Planning Application 3/2012/ 0834

Proposed agricultural Building at The Old Sewer Works, Sabden

Following discussions at the Parish Council meeting on 6th November I write to advise that Sabden Parish Council OBJECT to this application as they have a number of concerns

LOCATION PLAN

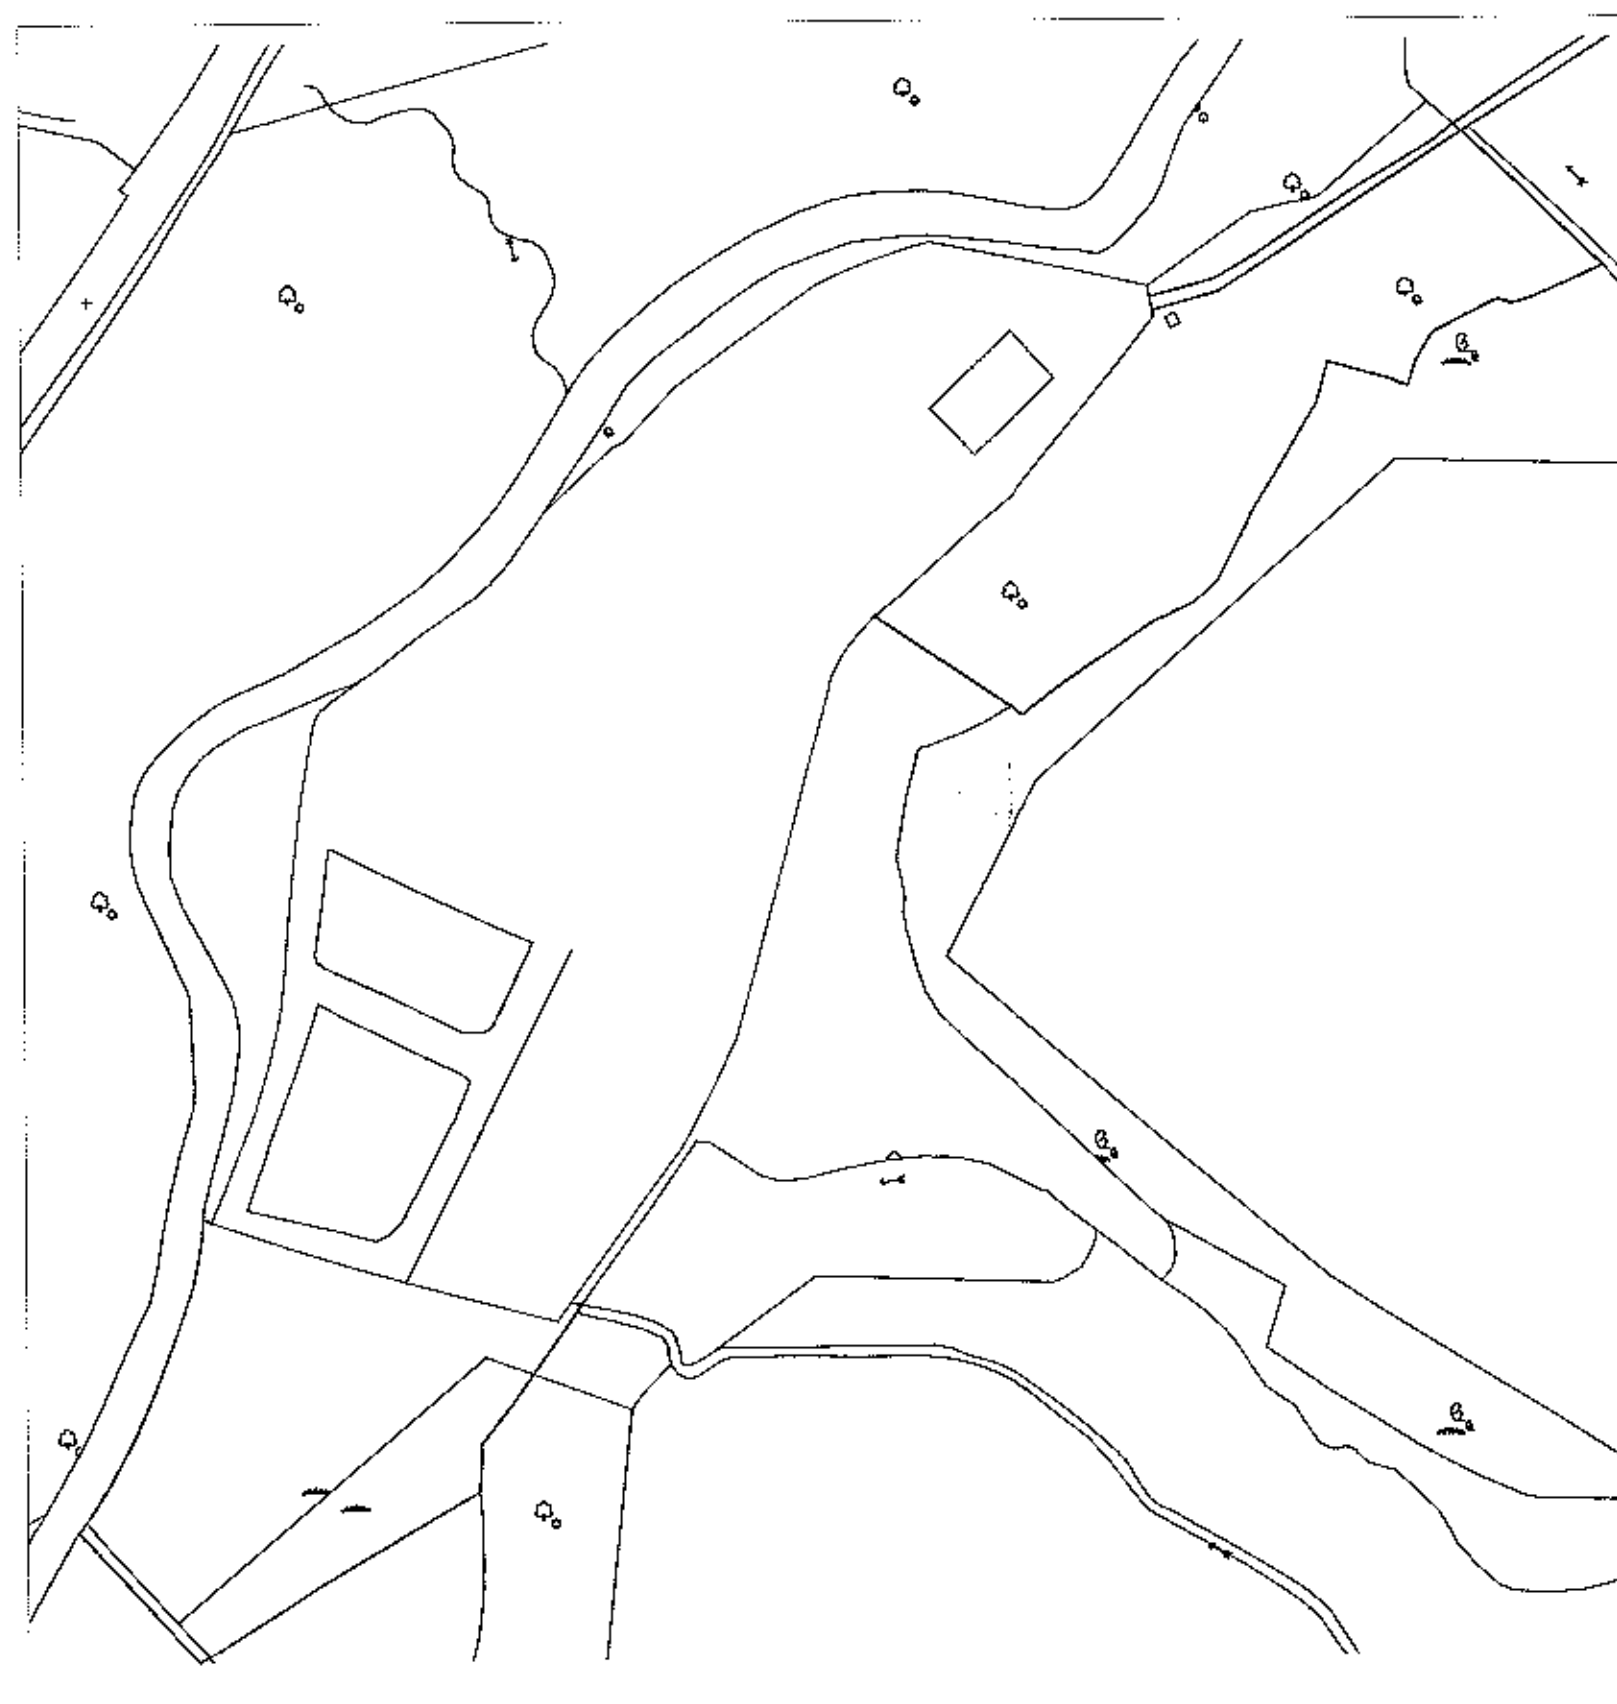
The application refers to a cottage nearby & plans show 1 Lamb Row which is currently derelict

SITE PLAN

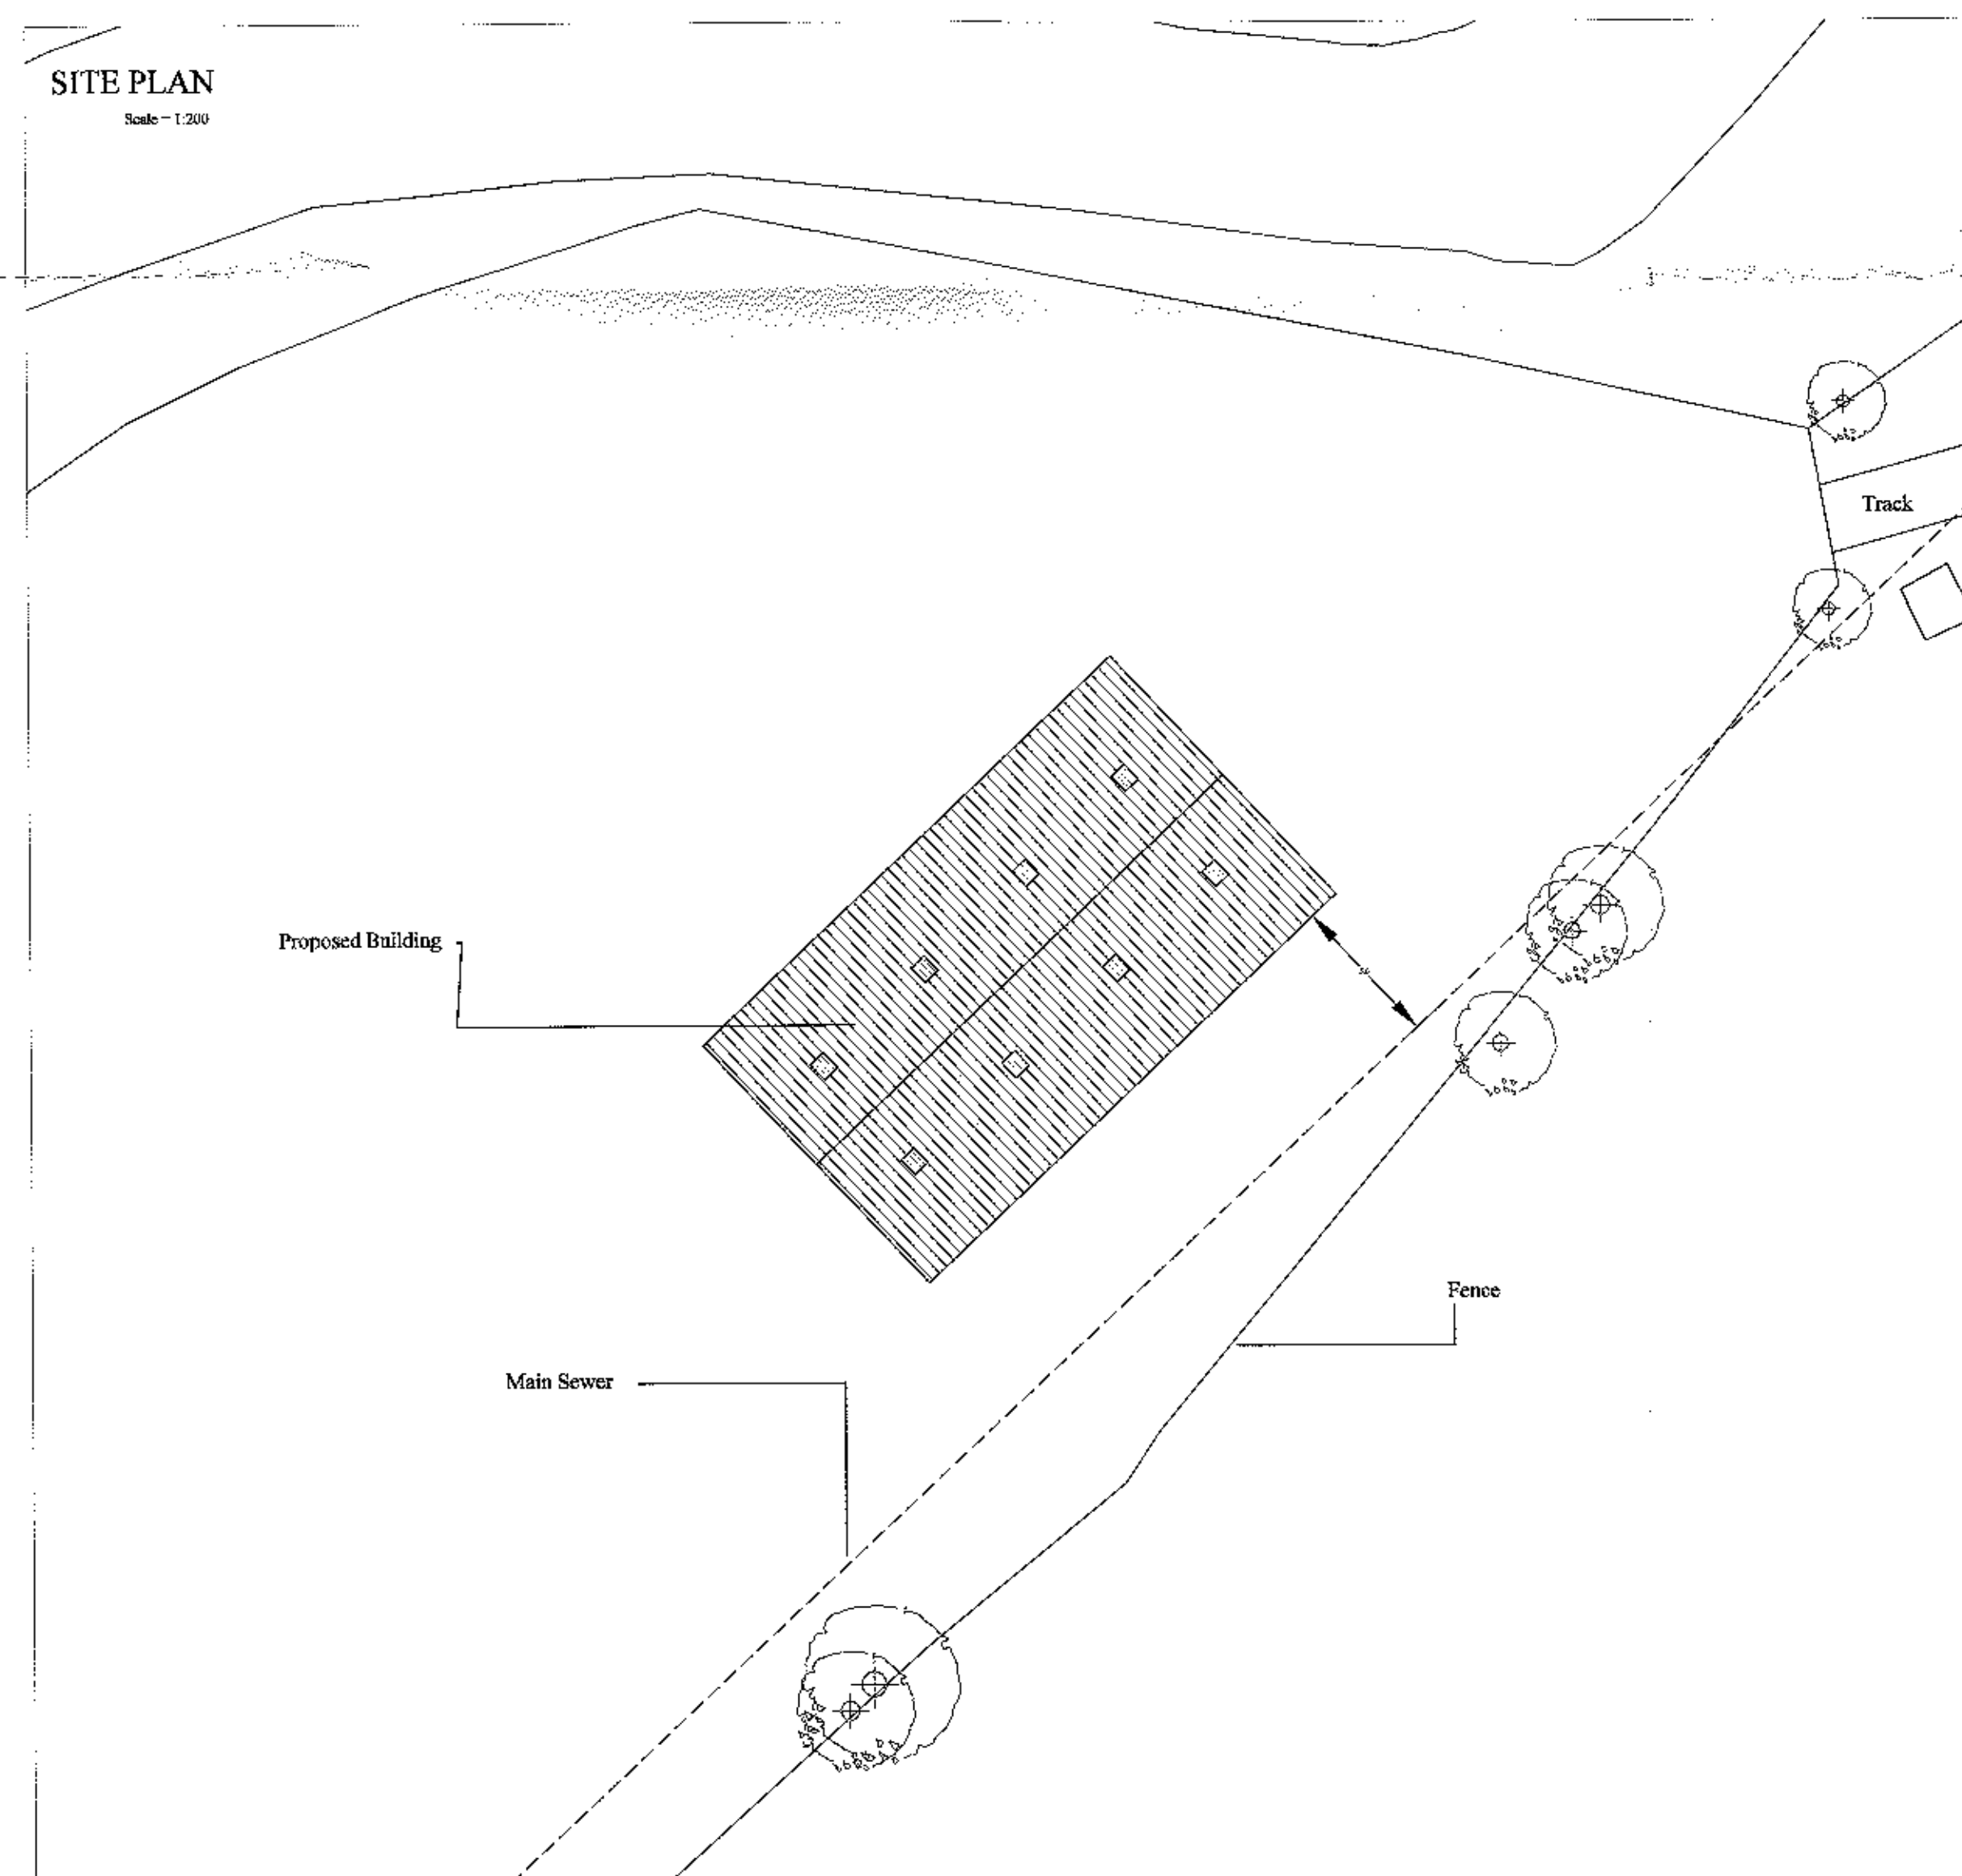
The proposal is sited very close to Sabden Brook

There is no provision made within the application for the disposal/storage of the muck/waste.

Councillors are concerned about 'run off' (dirty water/effluent) from the building into the water course
